Subject: FW: Planning Consultation on: BE/137/18/PL

Engineers Comments Regarding Surface Water Drainage

Proposed Site Layout Plan

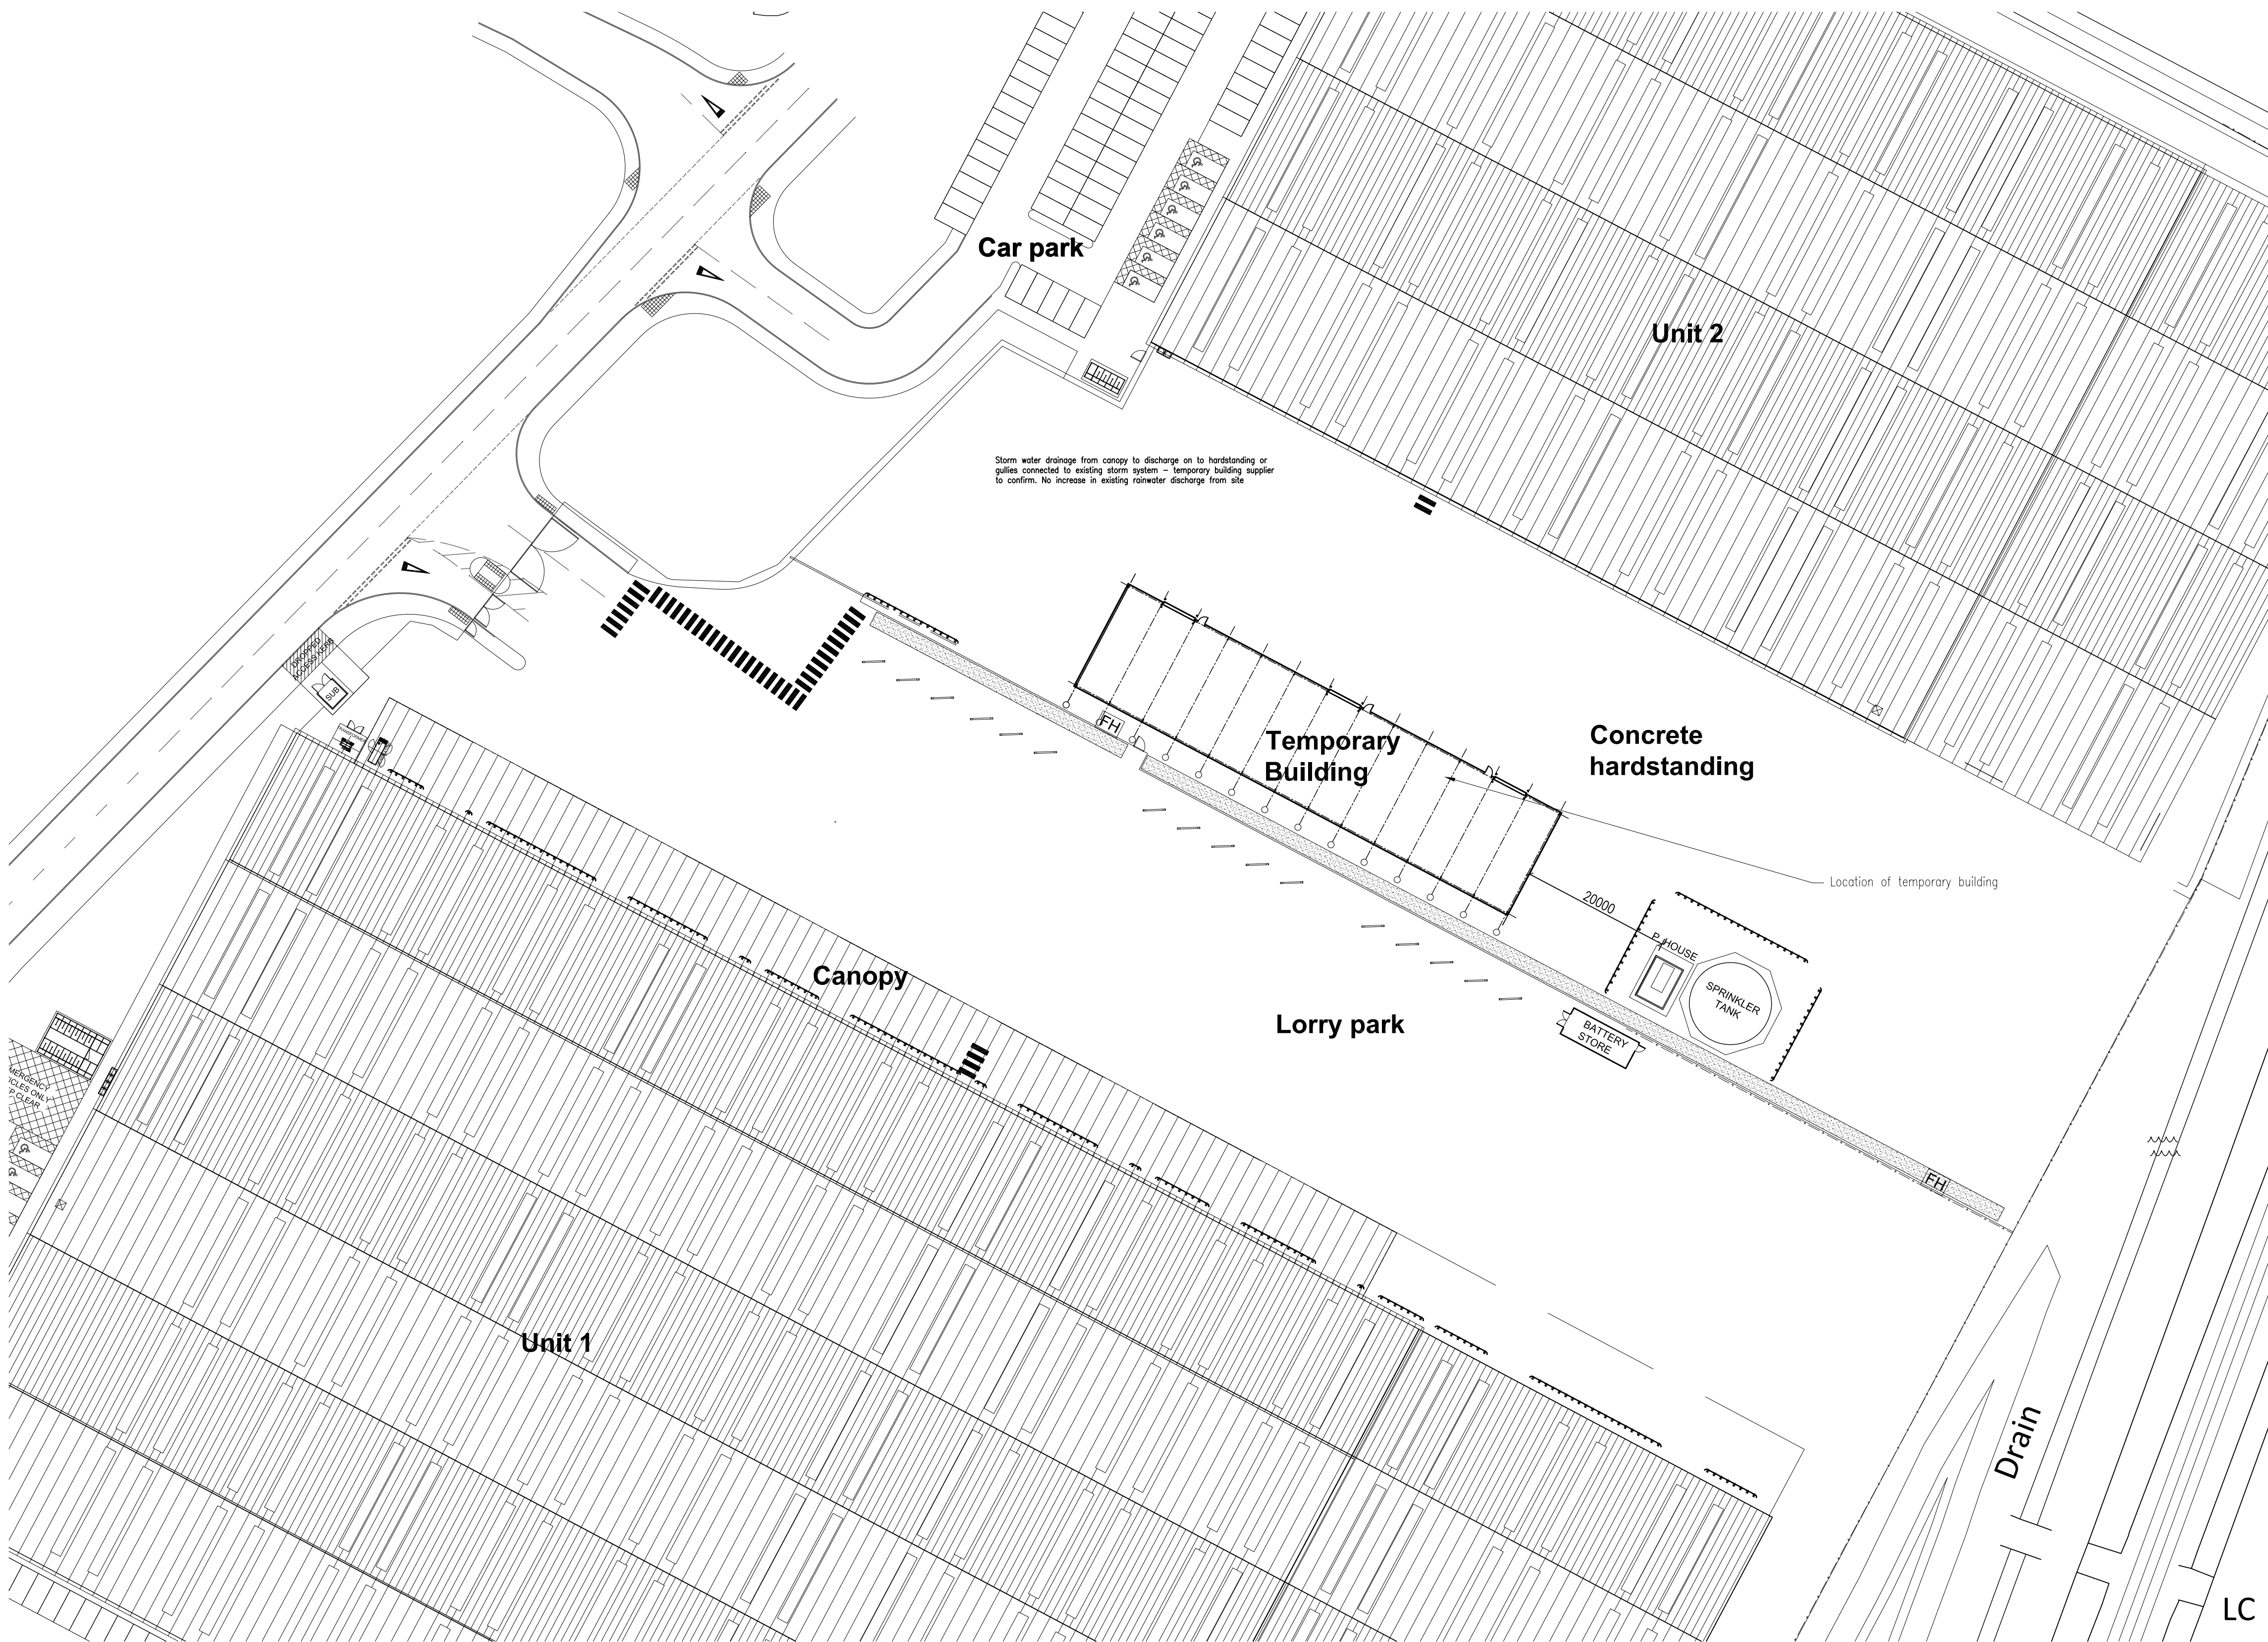
We require confirmation that the proposed temporary structure will not be located directly on top of the existing surface water drainage network. Please can the applicant provide as built survey of the surface water drainage network.
